Land at Bilsham Road, Yapton
Planning Reference: Y/70/22/DOC

Approval of details reserved by condition imposed under ref Y/91/17/OUT relating to Condition Nos 9 - surface water drainage and 27 relating to levels.

At this stage we would recommend that these conditions are not discharged at this time until further information is provided and the comments below are addressed

HEADWALL PLAN (S60 & S111)
(1:20)

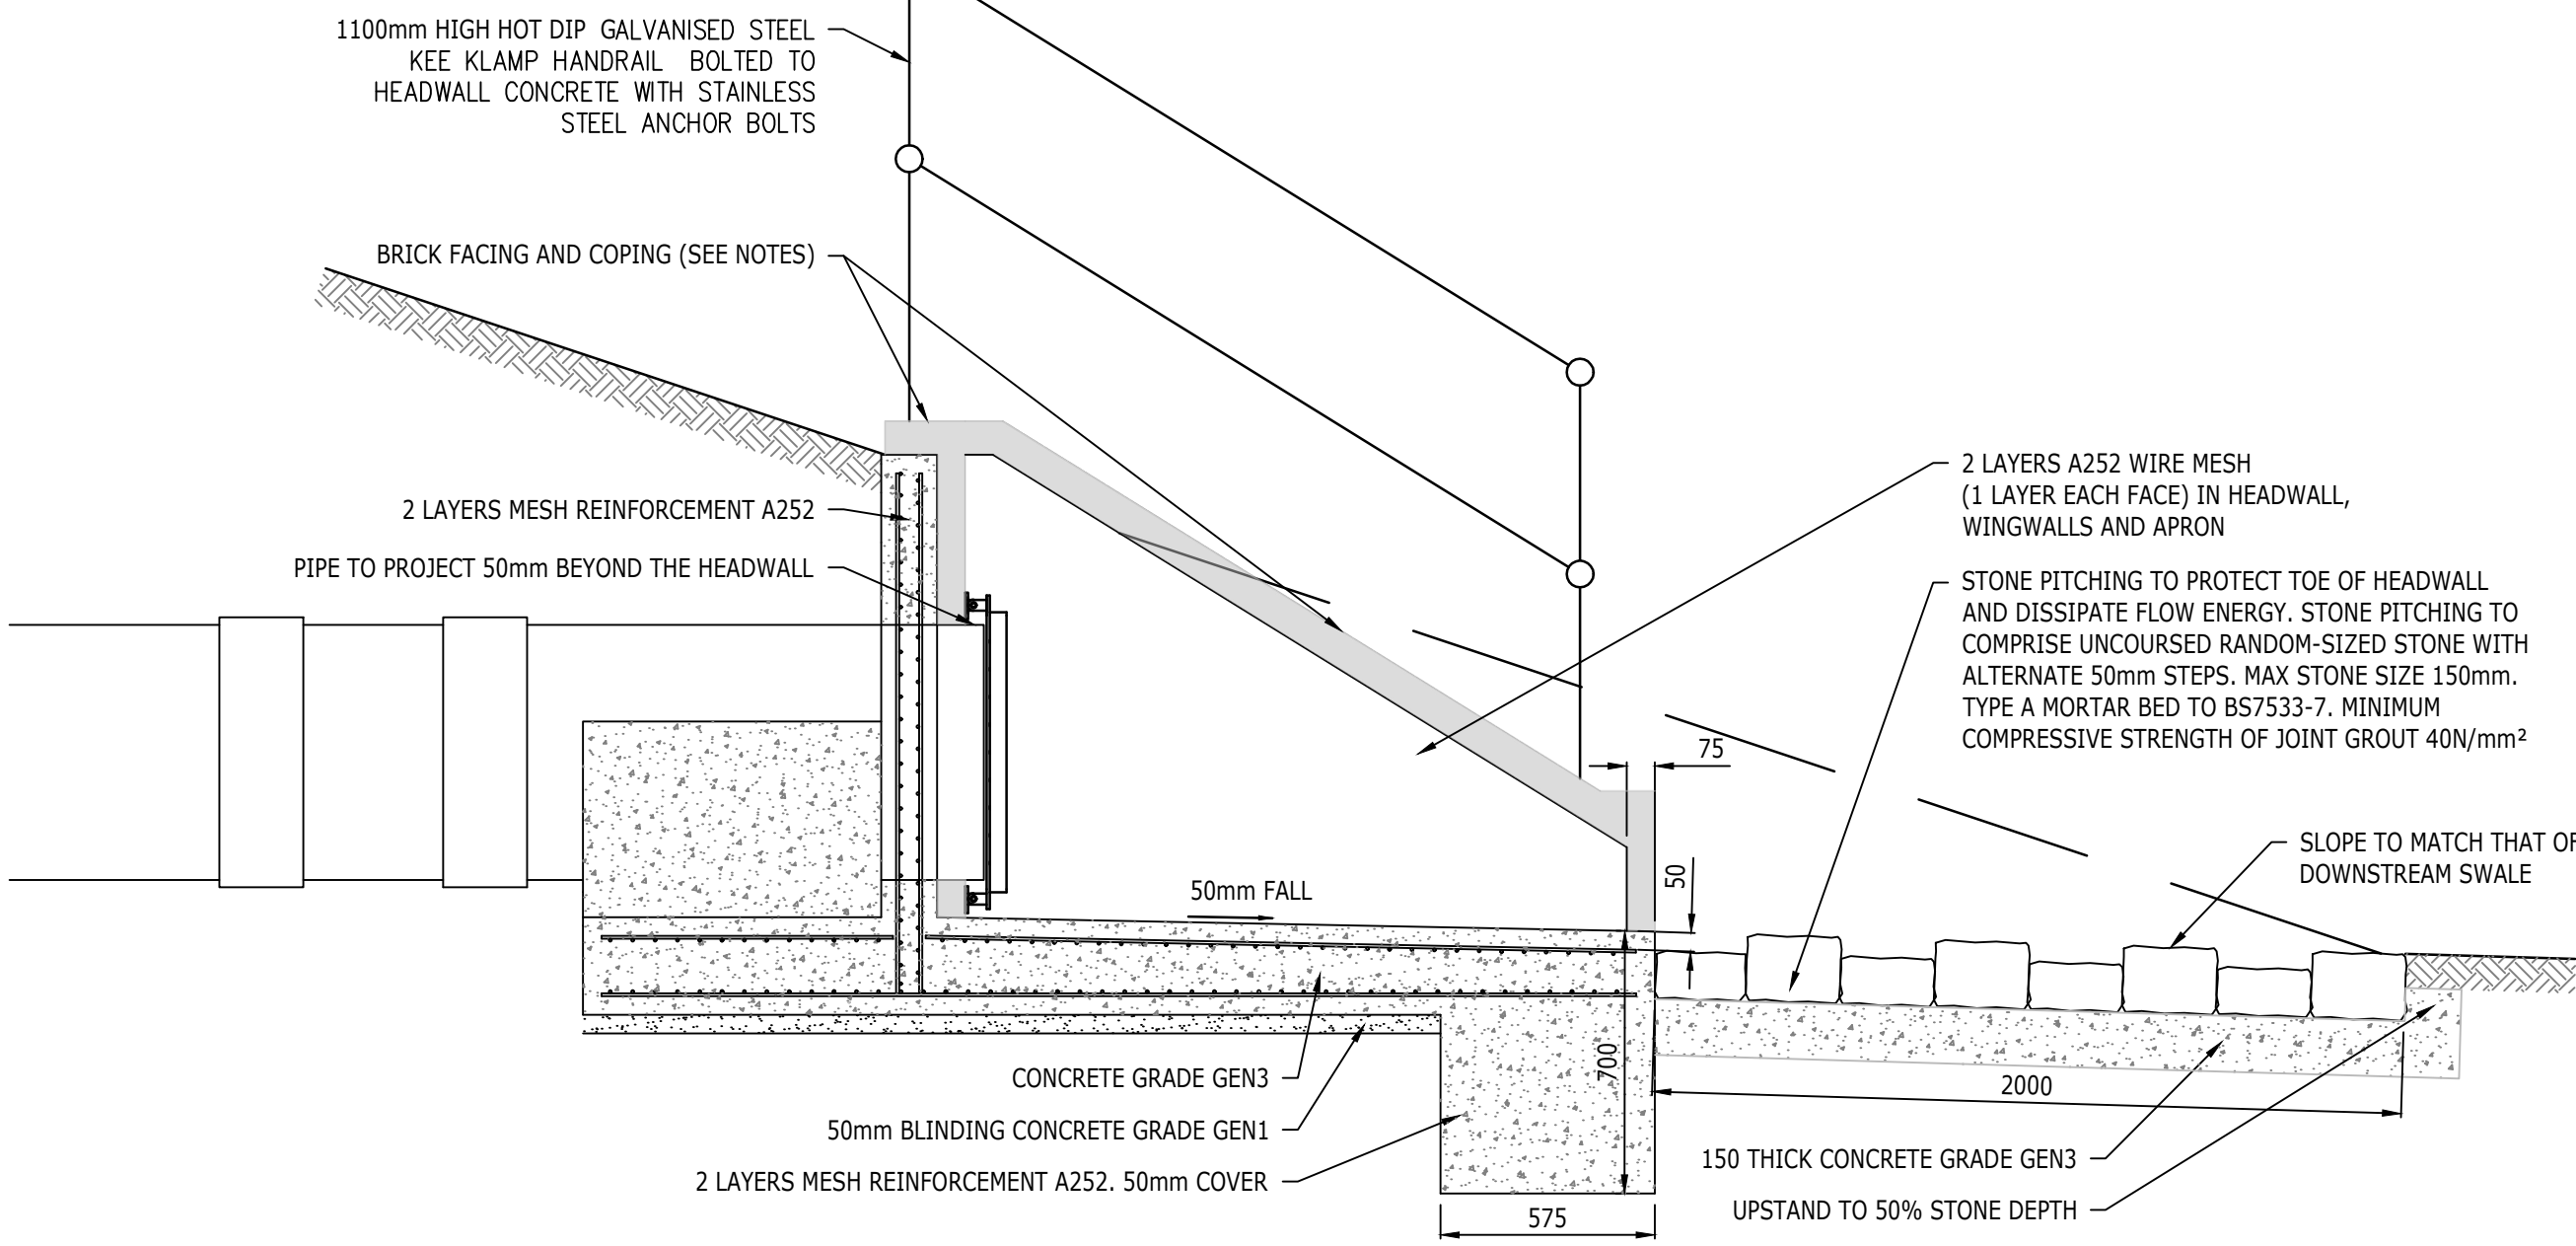
11. *Please provide cranked grilles at a 45 degree angle. - Cranked grilles required on heads – S104 Construction details sheet 1 of 2 D1956-15-100 needs to be updated to suit ADC requirement. Pipe beddings details on this drawing are illegible in parts. Information needs to be clearly presented. We note that applicant’s response that this is not “DSG compliant” however the drawings refer to Sewers for Adoption 7th Edition. As such the applicant needs to be clear which edition of Sewer for Adoption the adoptable drainage is being designed to.*

In addition they should confirm who the adopting authority will be as well as confirmation from the adopting authority on whether they will or will not accept cranked grilles.

08/02/2023- Whilst it is noted that the Technical Approval certificate has been provided for information, this doesn't clarify whether the adopting authority has considered a request to use cranked grilles. This needs to be confirmed by the adopting authority otherwise cranked grilles should be used
